Table 1 – Response to Submissions Received During Exhibition

Note: The Responses to Submissions Received during Exhibition have addressed the modified Project Application as they apply to the amended site area.

ROAD PROFILE 5

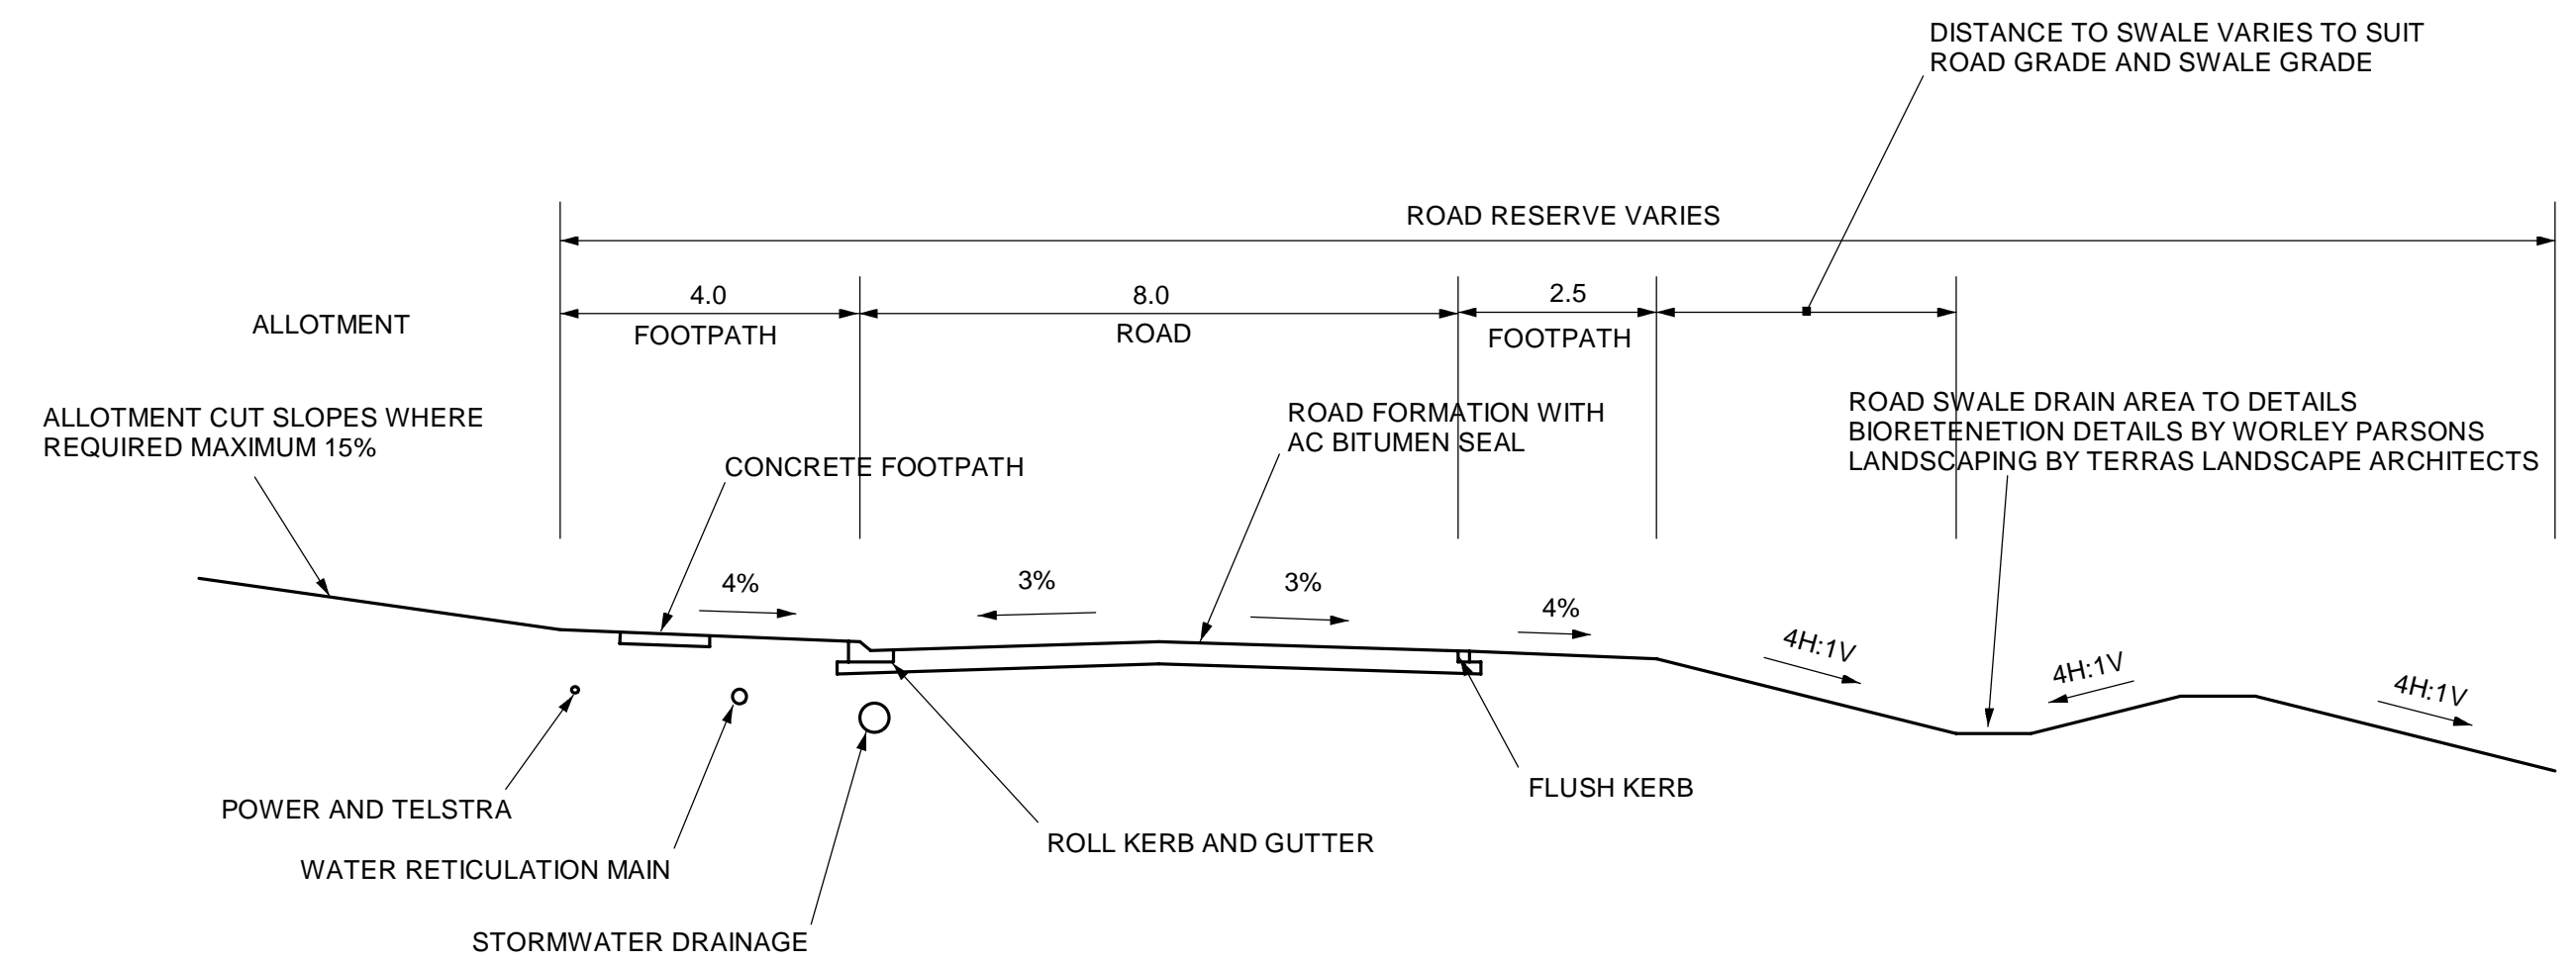
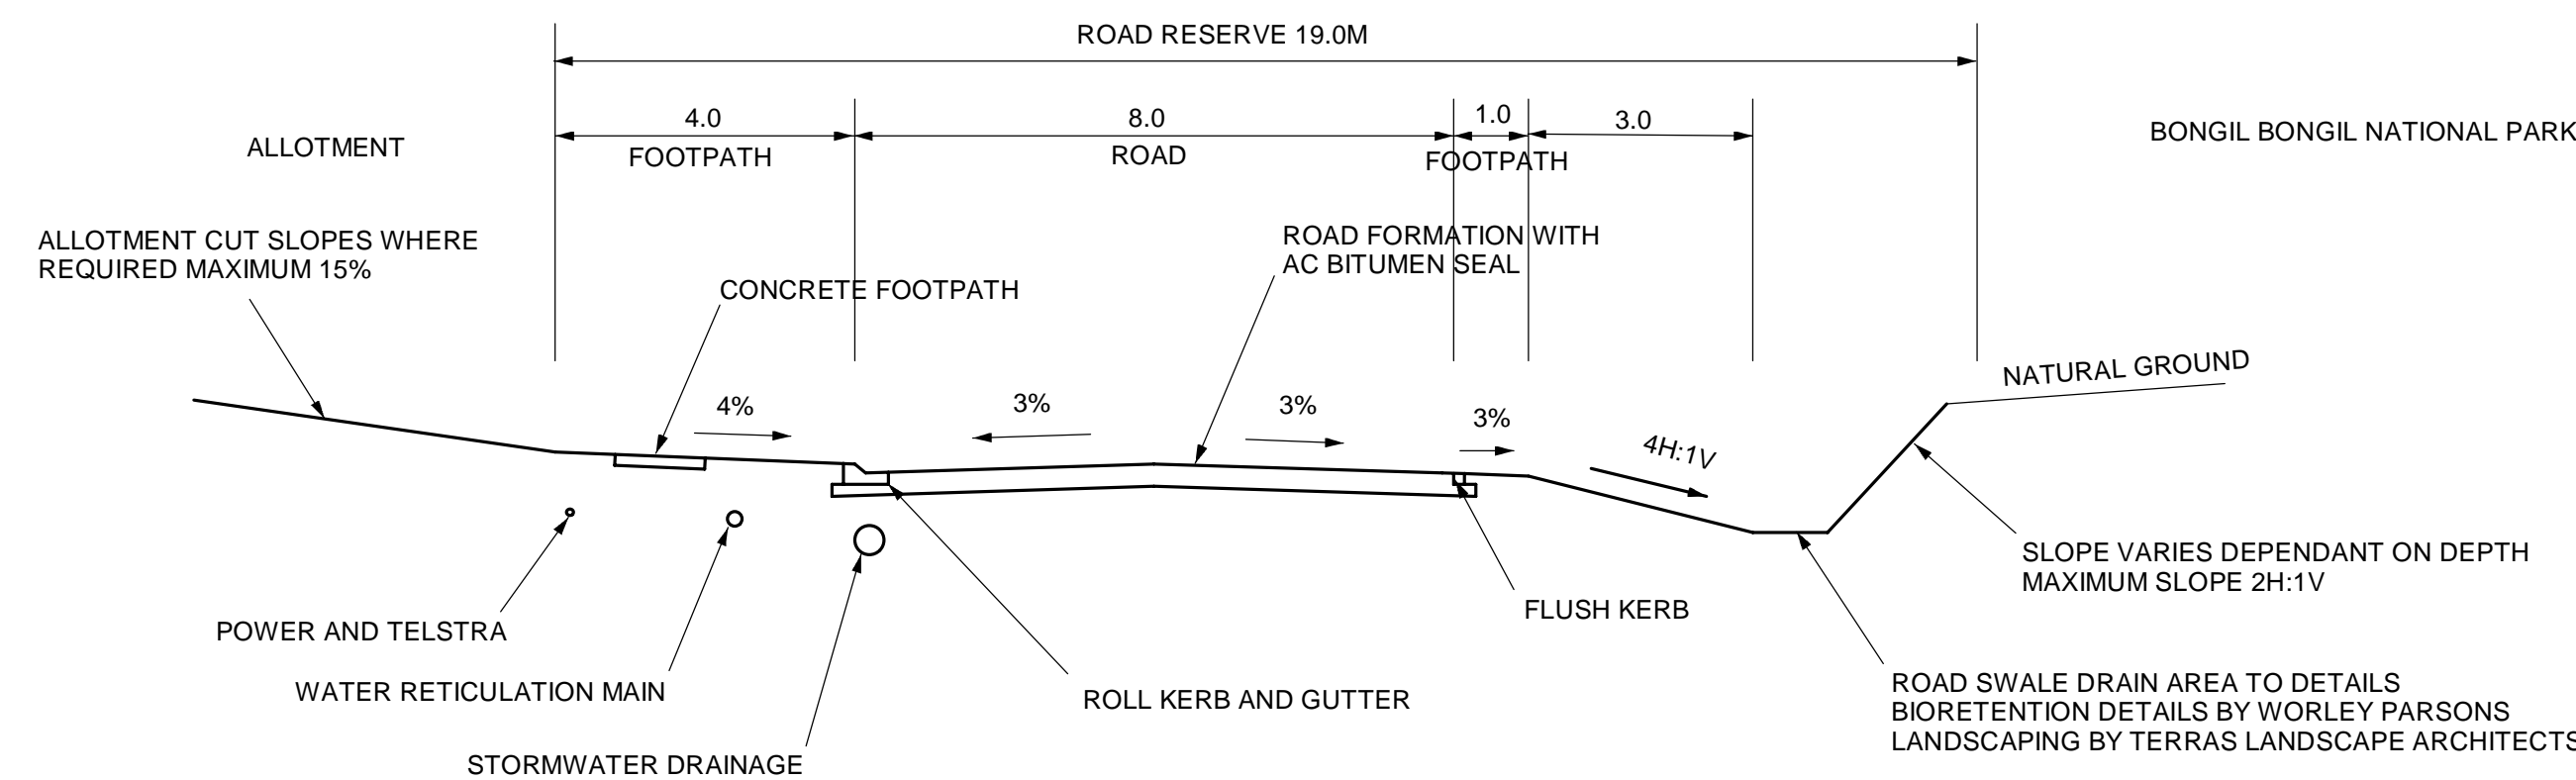
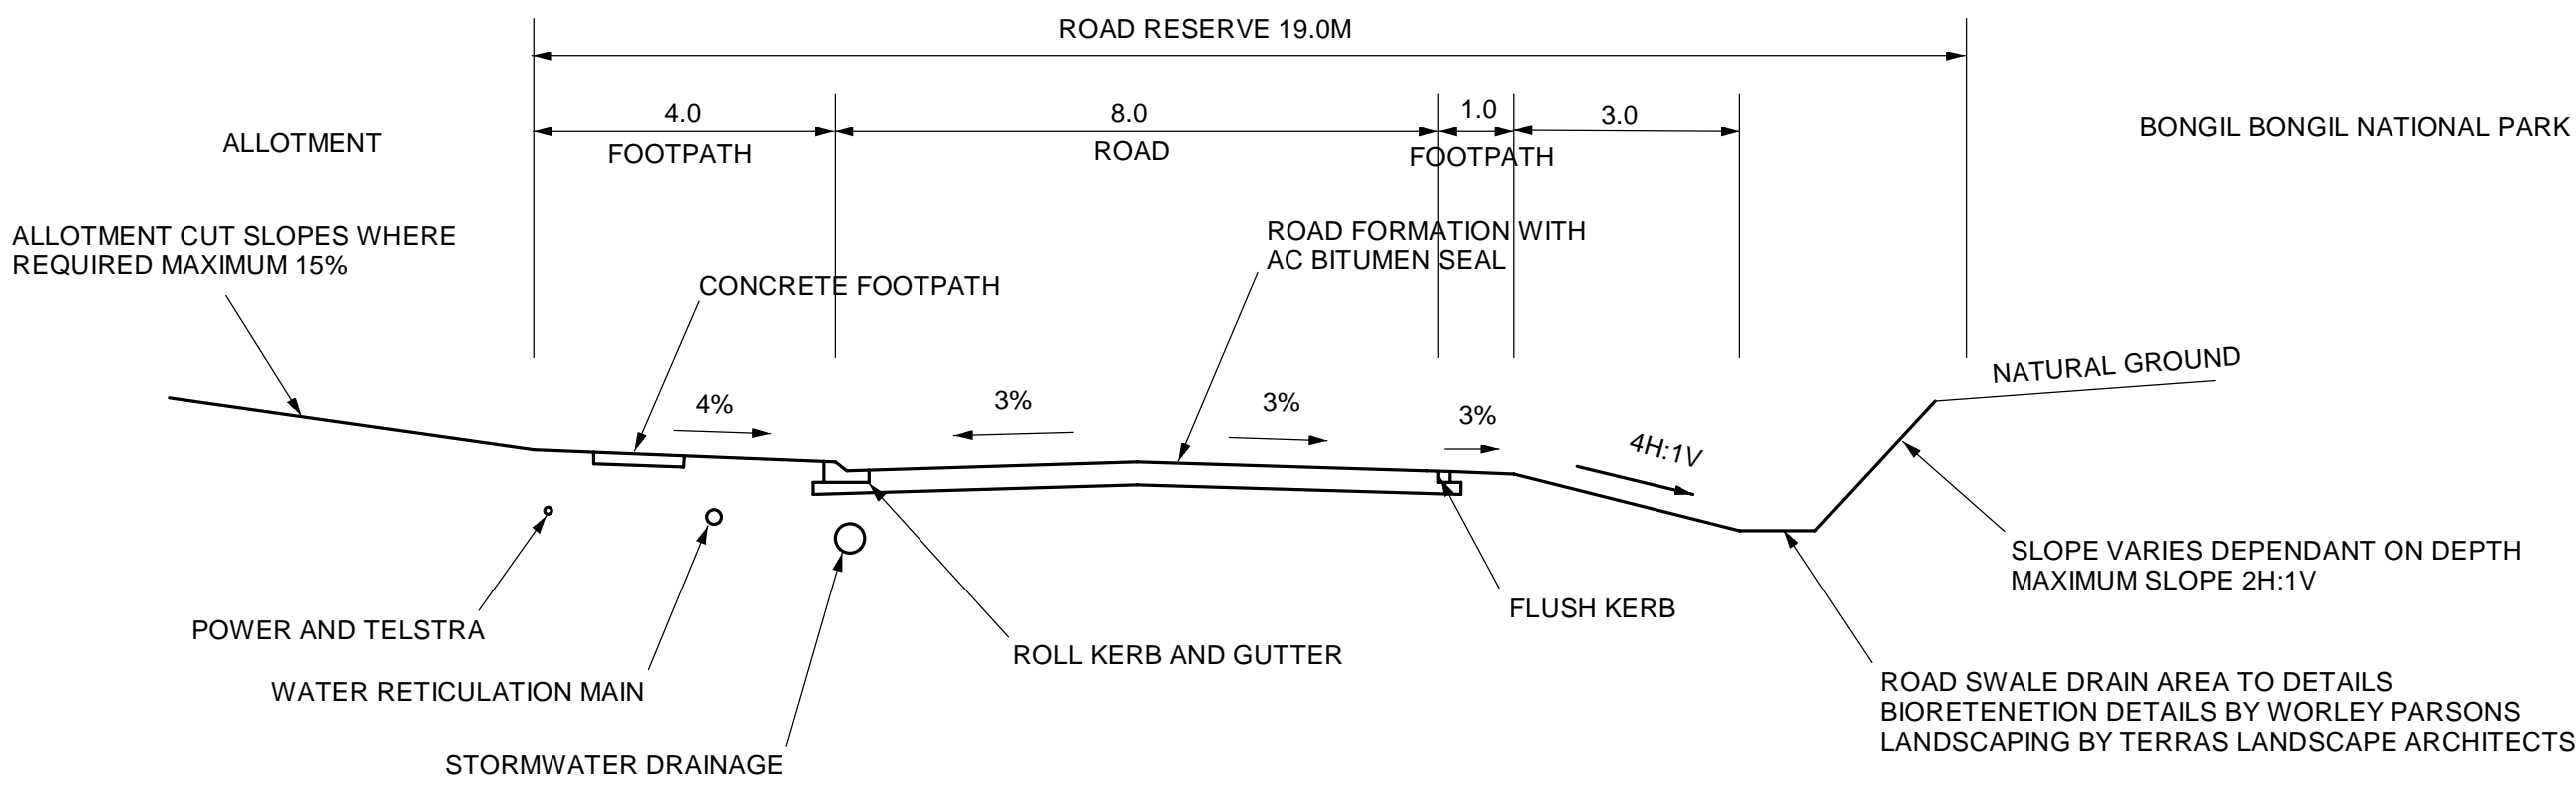
<ul style="list-style-type: none"> Road profile number 7 indicates that the perimeter road has a proposed carriageway width of 7 metres. The requirement is 8 metres similar to proposed Roads 5 & 6; 	Road Profile number 7 has been increased to be 8 metres in width.	No
	<ul style="list-style-type: none"> Suitable turning provisions shall be provided at the eastern end of Road 8; 	The redesign of the subdivision layout has incorporated the requirement for cul-de-sacs to have a 12m radius turning circle (24m diameter).	No
	<ul style="list-style-type: none"> Is the Road 8 loop road proposed as a one way road; 	The road layout has been amended to create a cul-de-sac (dead-end road) to the northern part of the site.	No
	<ul style="list-style-type: none"> The use of fire trails in the adjoining land to the east and south of the site 	The National Parks and Wildlife Service were consulted on	No
